16 June 2026

Subject: Open Water Surf Facility (SSD-7942 MOD 7) – Request for Advice

The Sydney Olympic Park Authority (Authority) has reviewed the documentation submitted in support of the application and raises concerns regarding the scope of works, remediated lands, and landscaping and public domain.

PLANT SCHEDULE

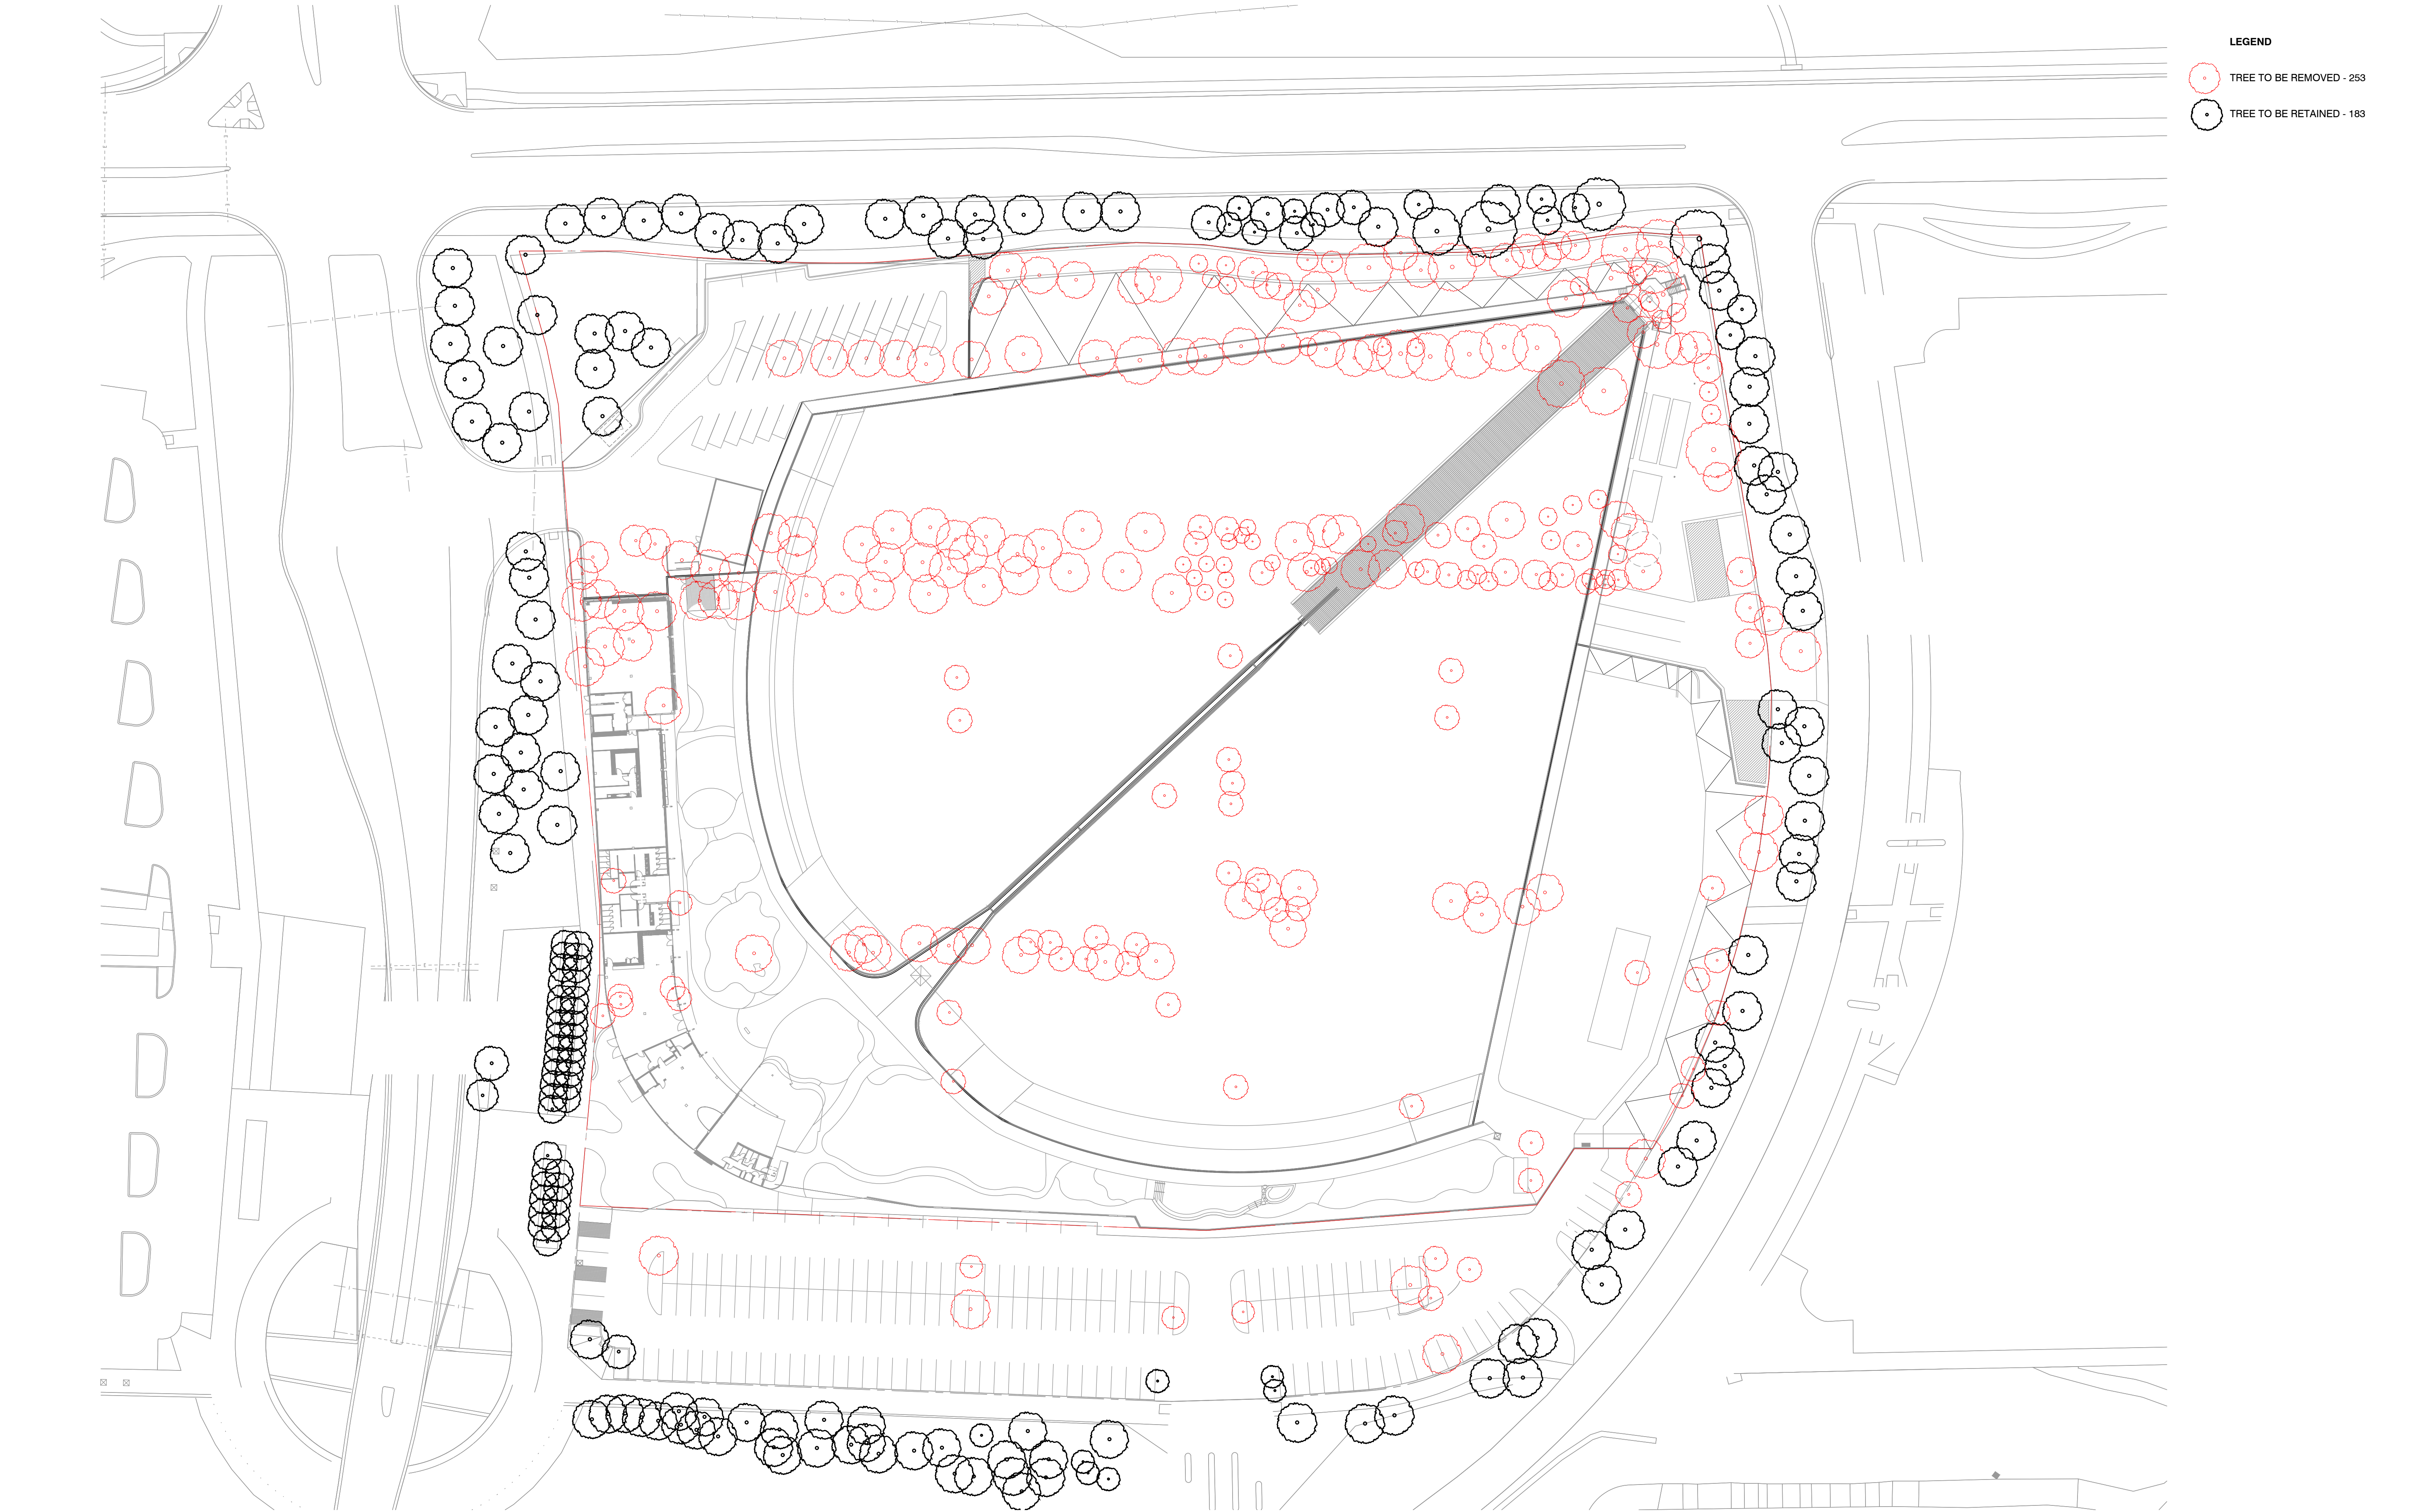
It is noted that the Report on Slope Stability & Soil Bearing Capacity of Landscape Mound Batter prepared by Oz Geos includes a recommendation that “the entire events lawn to be inspected once a month or after any significant storm event (with rainfall above 20mm). This is inconsistent with the proposal to have the events hill landscaped with a variety of planting instead of lawn as per the planting schedule.

The proposed layer of topsoil is shown as having a depth of 150mm. This depth is insufficient to support any vegetation except for lawn and the planting schedule provided is incompatible with the proposed topsoil depth. The thin layer of topsoil will dry quickly, negatively impacting any vegetation planted in it, requiring additional irrigation devices to support the healthy growth of the vegetation.

The Authority notes that the Landscaping Drawing provided in support of this modification application does not include a Planting Plan.

Recommendation: The topsoil depth is increased to a minimum of 300mm.

Recommendation: A Planting Plan is prepared clearly illustrating the location of each of the proposed plant species and is provided to the Authority for review.

DRAWING
LANDSCAPE RENDERS

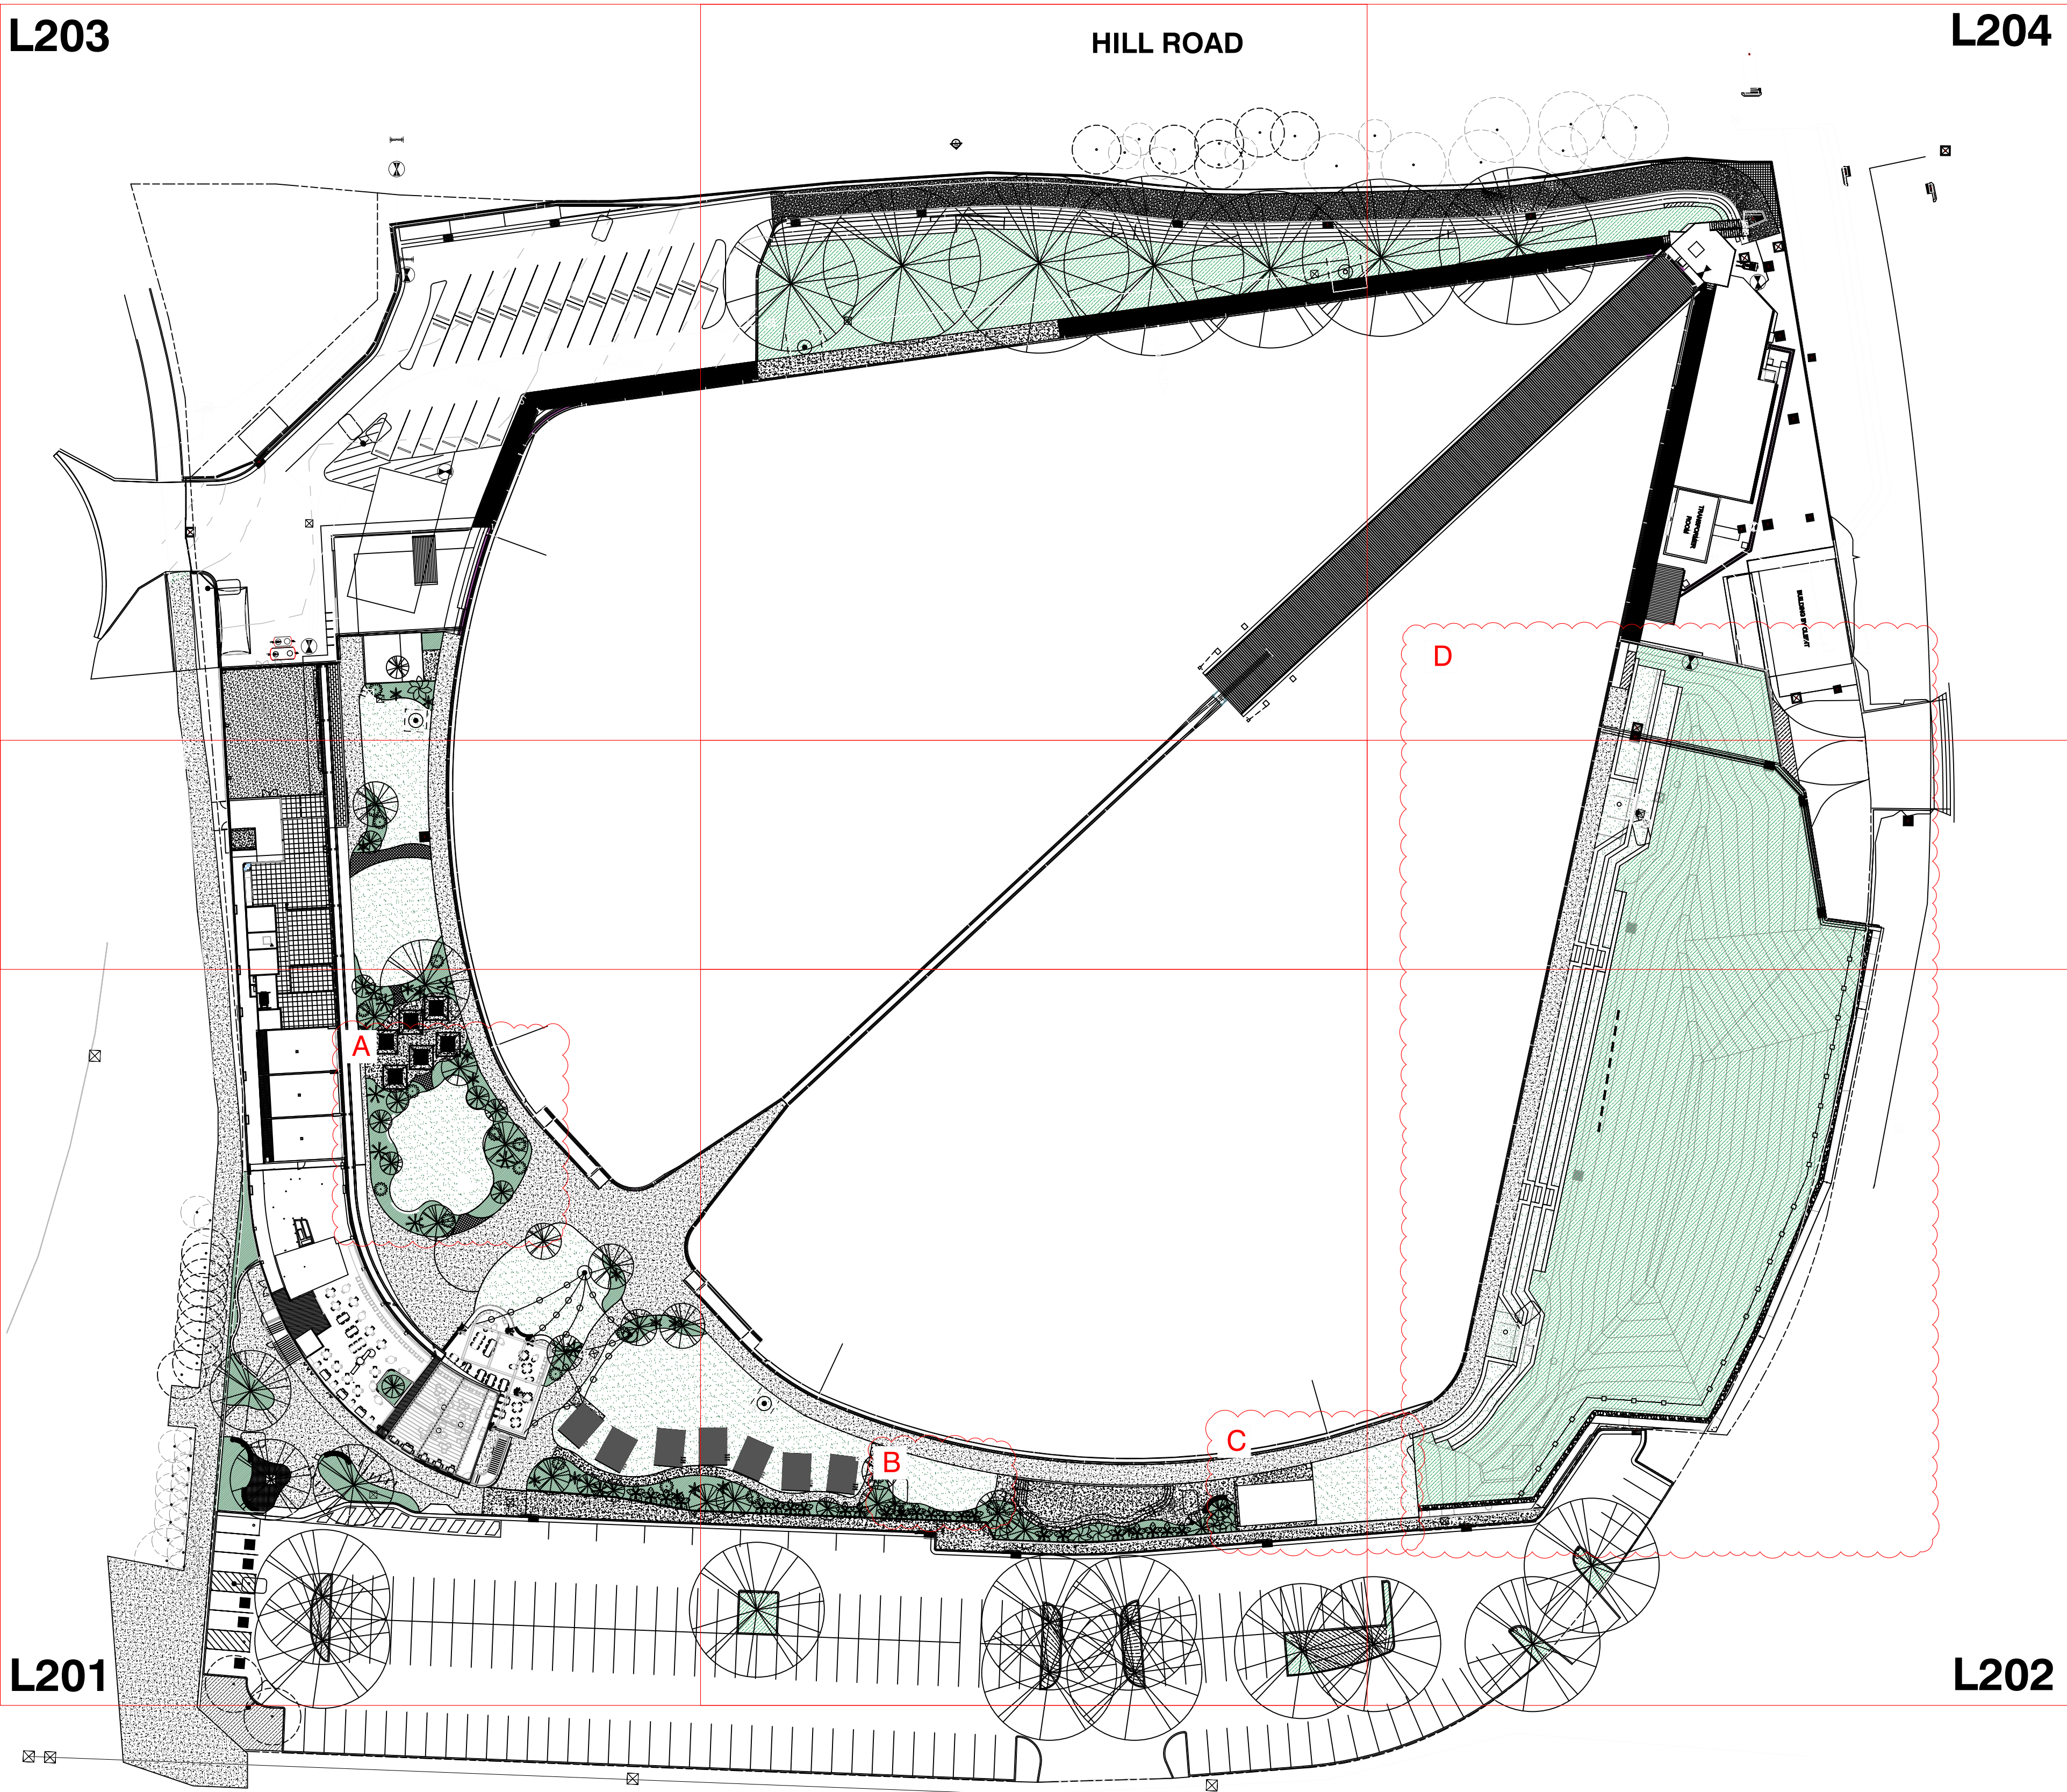
The Amended Landscape Plans prepared by Oculus and submitted in support of this application illustrate additional signage on the events hill which is not supported by the Authority.

Recommendation: The event hill signage be removed from the landscape plans and no additional signage is approved as a part of this modification application.

DRAWING
SECTIONS AND ELEVATIONS

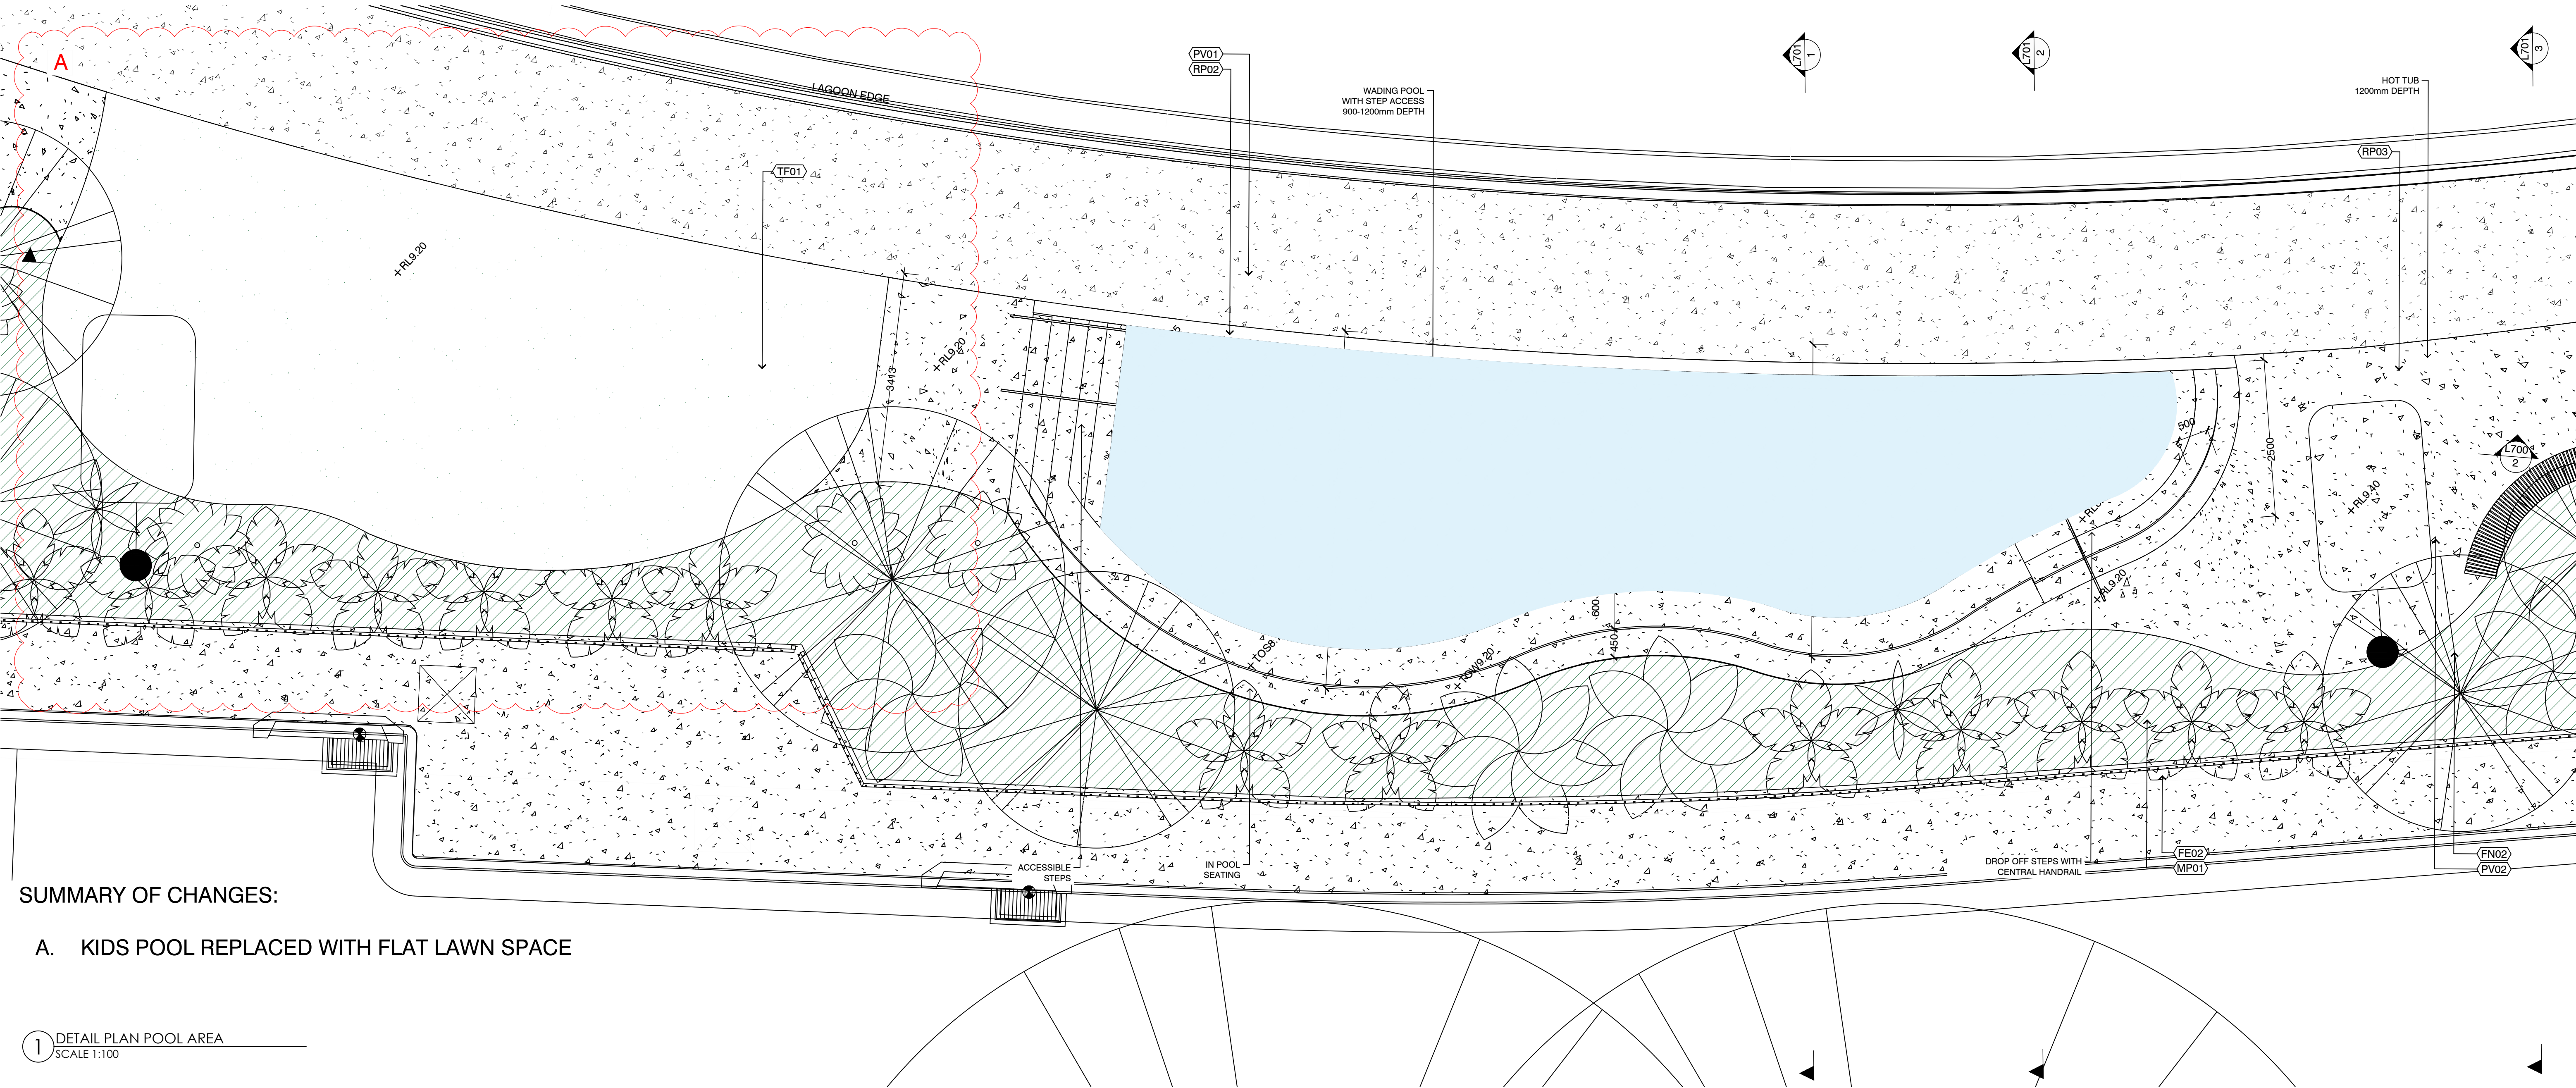
The Authority notes that a security fence on the proposed hill is shown in several drawings, off set 1500mm from the proposed gabion wall. These drawings do not provide sufficient details on the footings of the proposed fence. The footings of the fence may impact the proposed capping layer and associated drainage.

Recommendation: The drawings are updated to include information on the footings supporting the fence.
